Ecology Comments

Date: 07/03/2025

Address: Land at Ford Airfield

F/16/24/RES: Approval of reserved matters following outline permission F/4/20/OUT for phase reserved matters 4 (south), for the erection of 357 No. residential dwellings plus associated roads, infrastructure, parking, landscaping, open space & play areas and associated works. This application affects a Public Right of Way, may affect the setting of a Listed Building and falls within CIL Zone 1 (Ford strategic site - zero rated).

Softworks 3 of 10
RM4

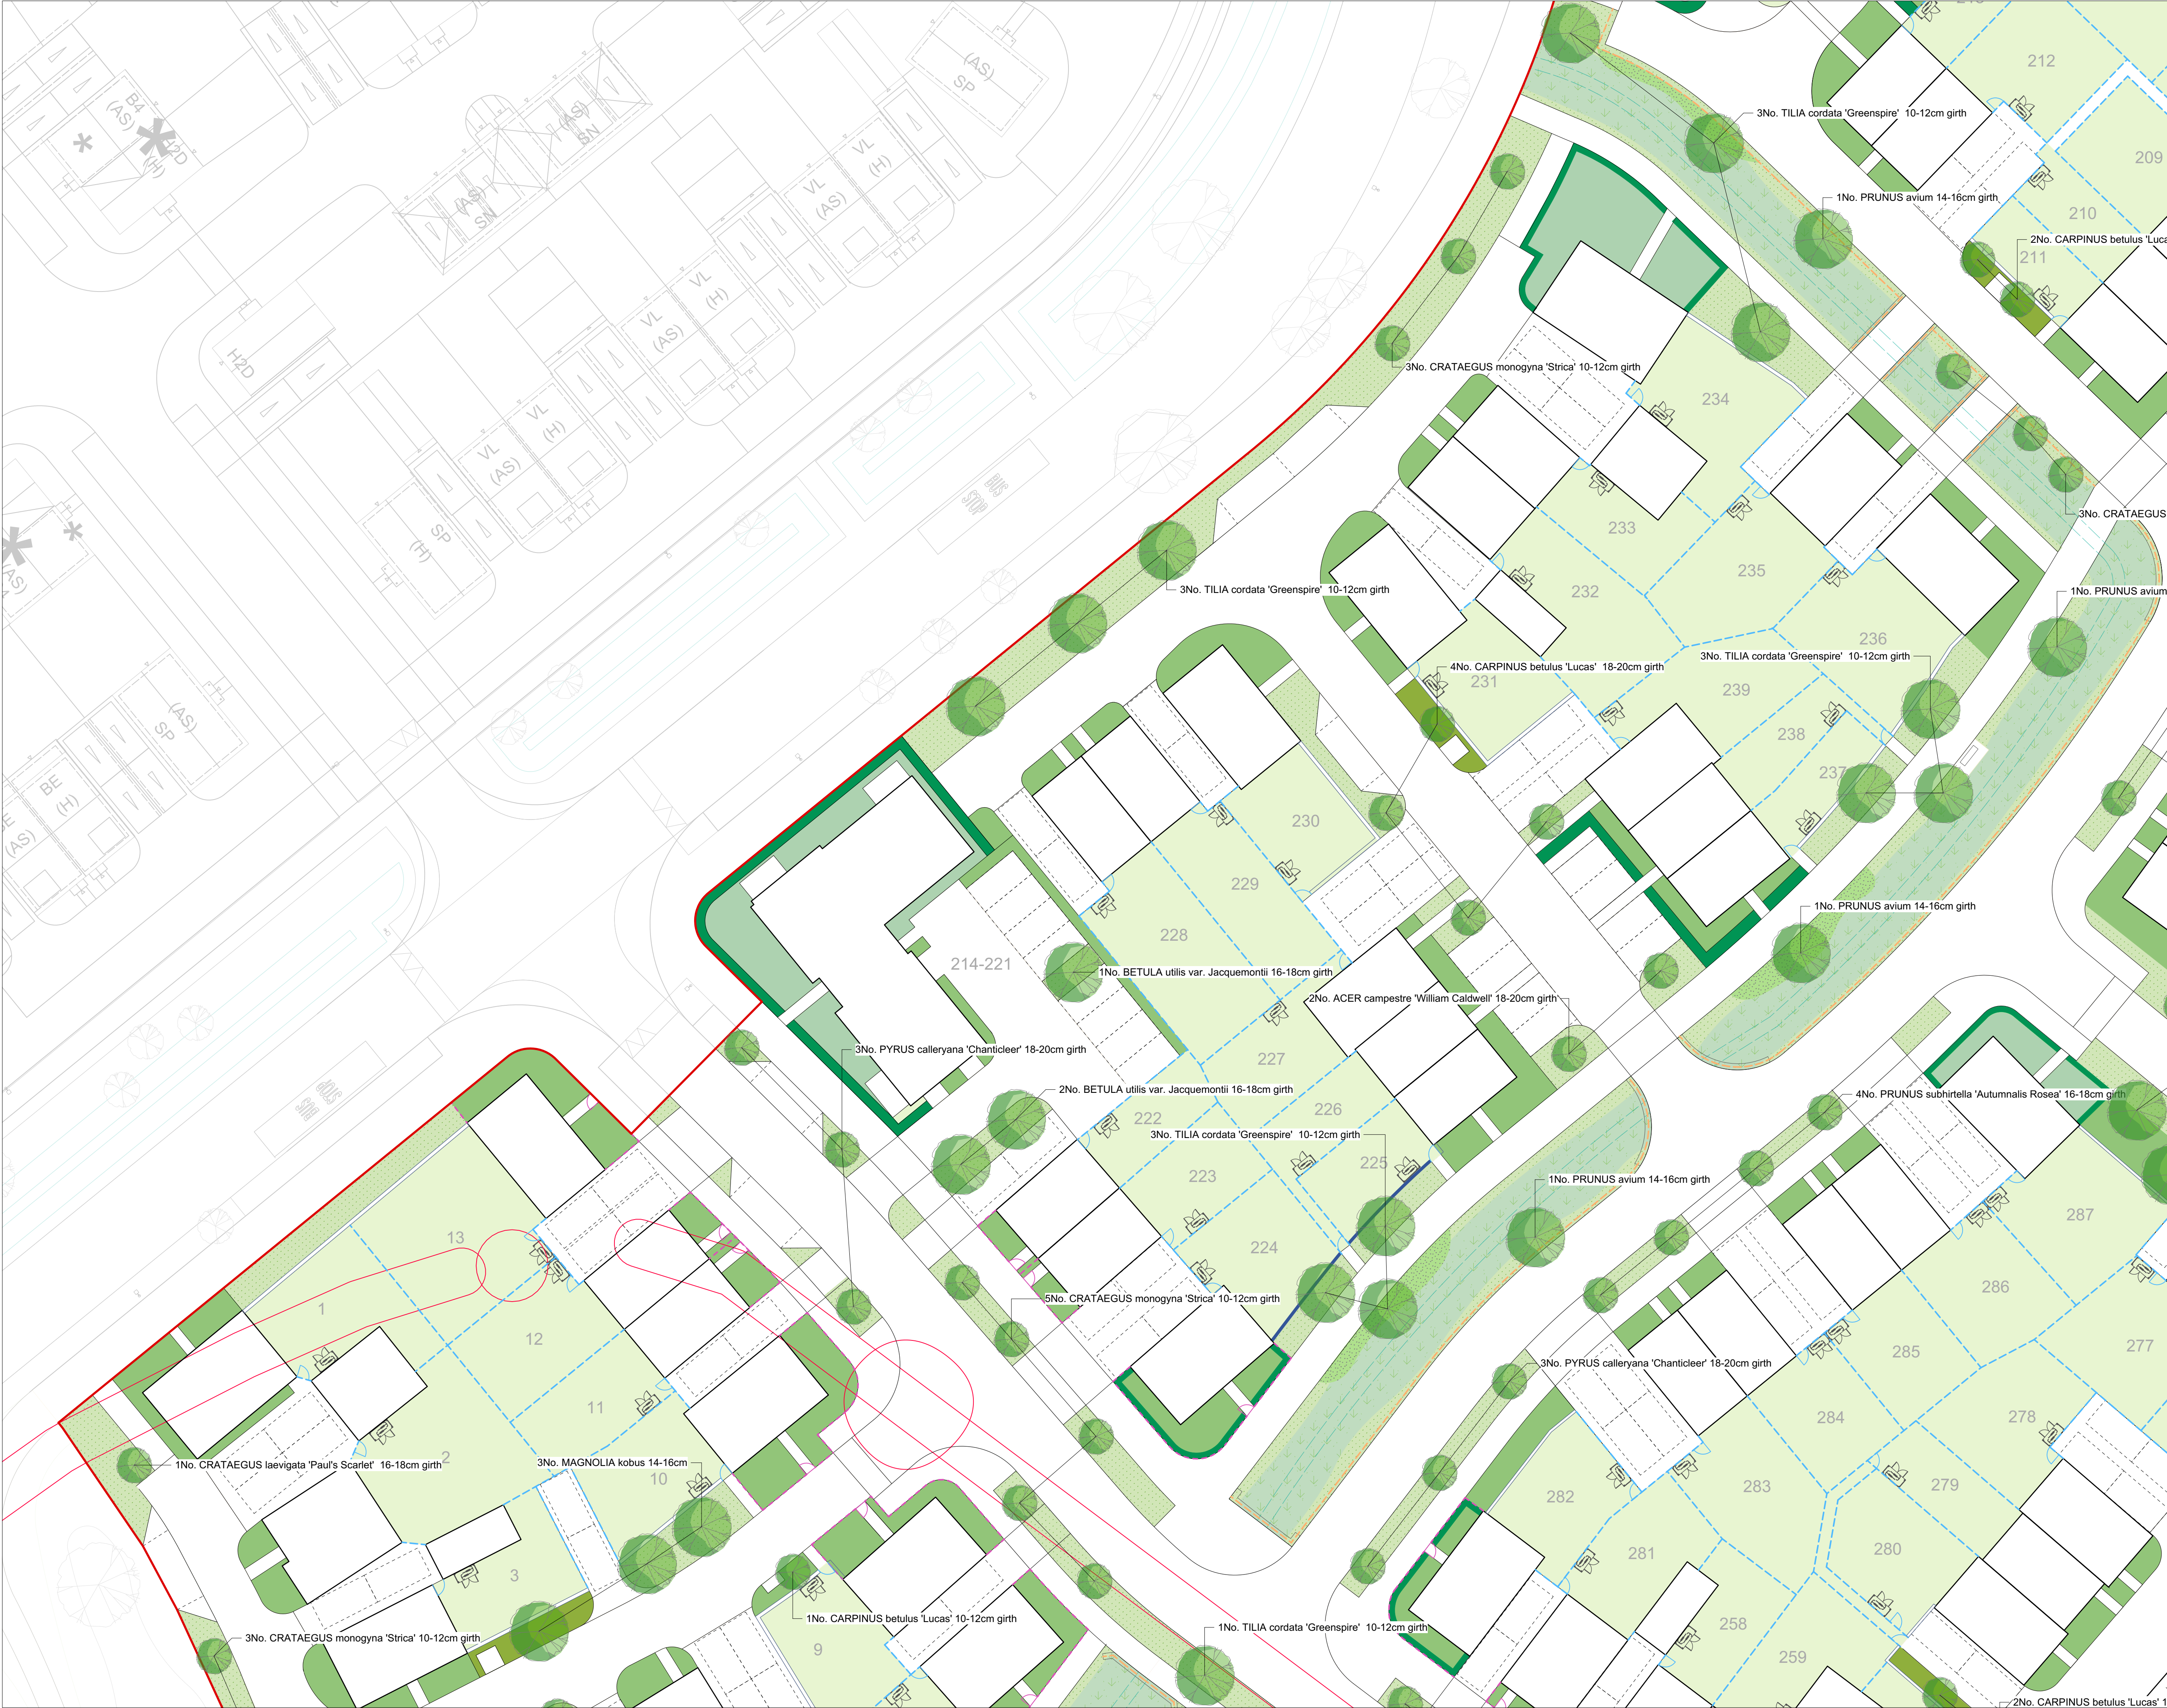
Native Hedgerows are proposed within the site; however, the ratio of planting does not allow for a 50% Hawthorn, which is considered a typical native hedgerow. Unless there are reasons of character that would support the currently proposed mix, the mix should be altered to provide at least 50% hawthorn.
